DECISION DELEGATED TO HEAD OF PLANNING

Application No: H20-0622-24 **Applicant:** Mr F Campling
Proposal: Proposed Residential Development - 2 Bungalows & New Access
Location: Adjacent To 2 Jarvis Gate Sutton St James Spalding
Terminal Date: 7th March 2025

INDICATIVE SITE PLAN

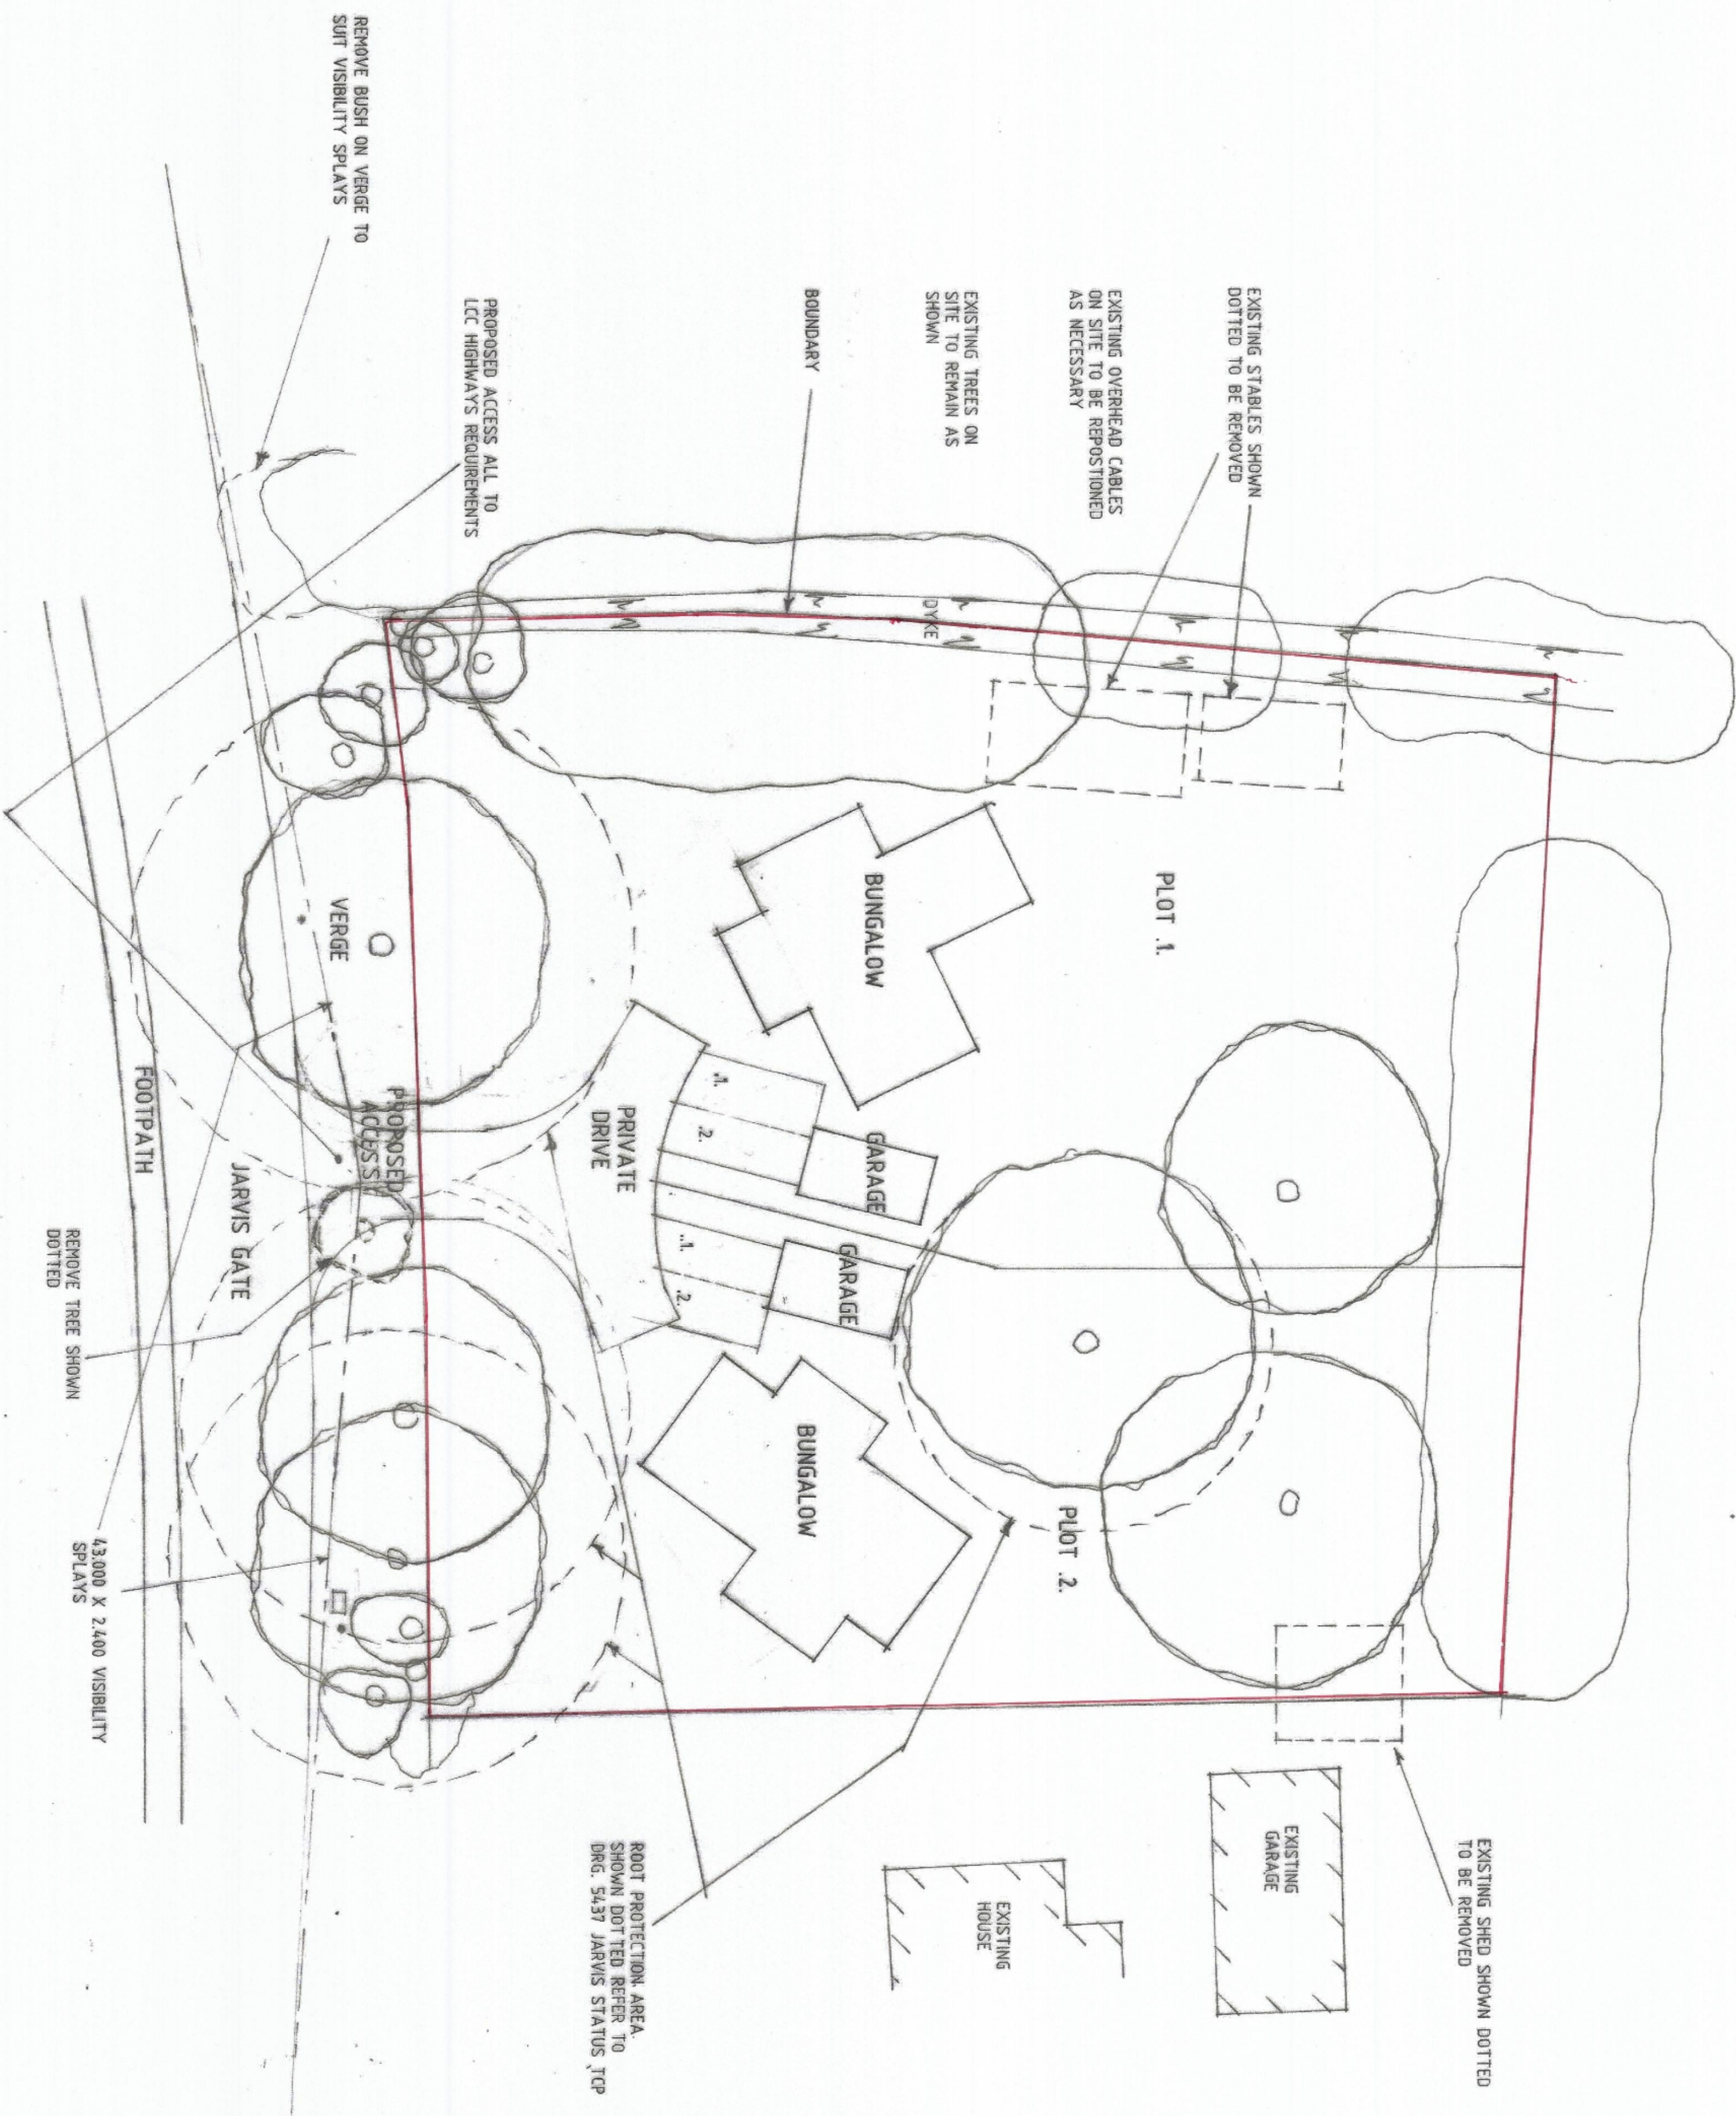
The proposed development is only acceptable if the dwellings can be designed outside of the root protection areas, and not inside them, as this would fail to overcome the previous reason for refusal.

As the site has extensive tree cover at the front, flank, central section and rear portion of the site, the root protection areas overlap. Taking into account root protection areas, there is very little of the site that would be able to be built on which do not affect some of the trees. Whilst the submitted drawing is indicative, it has been subject to extensive pre-application discussion following the earlier refusal. The conclusion was that two bungalows were possible on site but with just one access only that was shared, in order to minimise impacts on preserved trees. The existing field gate next to the very prominent Ash Tree at the front would need to be closed aswell, using a 'no dig' solution so that the root protection area of that tree is not adversely affected. The depth of the roots of this tree has been checked by the Tree Officer who has concluded that the stopping up of the access is possible and can be controlled via a condition. Therefore, whilst the layout is indicative, conditions should be attached to any approval to fix the access point and stop up the field gate access in order to minimise the impacts on trees.

In terms of impact on the street scene, some of the non preserved bushes at the front of the site have been removed, and this will mean that there will be a change to the street scene. The dwellings will also be more visible in the street scene and will be set further forward of the building line compared with the dwelling at 2 Jarvis Gate. Despite this, given that they are bungalows, it is considered that subject to a condition retaining the preserved trees at the front, the impact on the street scene for 2 bungalows would not be so severe as to warrant refusal. It would also be important to retain the trees along the flank to protect views of the neighbour and to preserve biodiversity on the site.

As the proposals are for bungalows, and are centrally located, as long as the flank and front boundary trees are preserved, it is unlikely that significant loss of light or outlook would occur. It is correct that they are forward of the building line. Two storey developments would be too prominent on the street scene as they are forward of the building line. However, as bungalows it is not expected the impact would be severe. A condition is suggested to ensure only bungalows are created.

The Local Highway Authority specified a shared access to be a minimum of 4.1metres. This is considered achievable. The existing field gate access will need to be stopped up which is required in highway terms but also required in terms of ensuring that only one access to the site is possible to minimise the adverse impact on preserved trees. Other conditions are suggested by the Local Highway Authority which suitably control the scheme with respect to highway matters.

The scheme has been designed to retain the preserved trees on site. Whilst the flank trees are not preserved, they still have biodiversity and amenity value, and as such a specific condition to retain them post development is suggested. A note on the decision is also suggested to make it clear that the trees should not be felled due to post development pressure.

The access and hard surface areas which are within the root protection zones should be hand dug, with minimal digging and cellular material beneath the finished surfaces should be used to minimise adverse effect on the roots of the preserved trees. These mitigations would assist with preserving the biodiversity of the site, particularly as additional credits are required in order to achieve 10% Biodiversity Net Gain. Restrictions on extensions are also required to ensure roots are protected from further development.

Two frontage trees were agreed to be felled as part of H20-1047-22. They are situated at the front of the site, one in the corner and another a few metres along the boundary. The decision notice was dated 19 December 2022 and condition 1 stated that the proposed work is carried out within 2 years of the date of that decision. As the trees remain this decision has therefore lapsed and the trees can no longer be removed. In view of the current application, it is considered that their retention is imperative since they assist in reducing the impact on the street scene given that the dwellings are set forward of the building line of the adjoining property. A condition is suggested therefore to retain them.
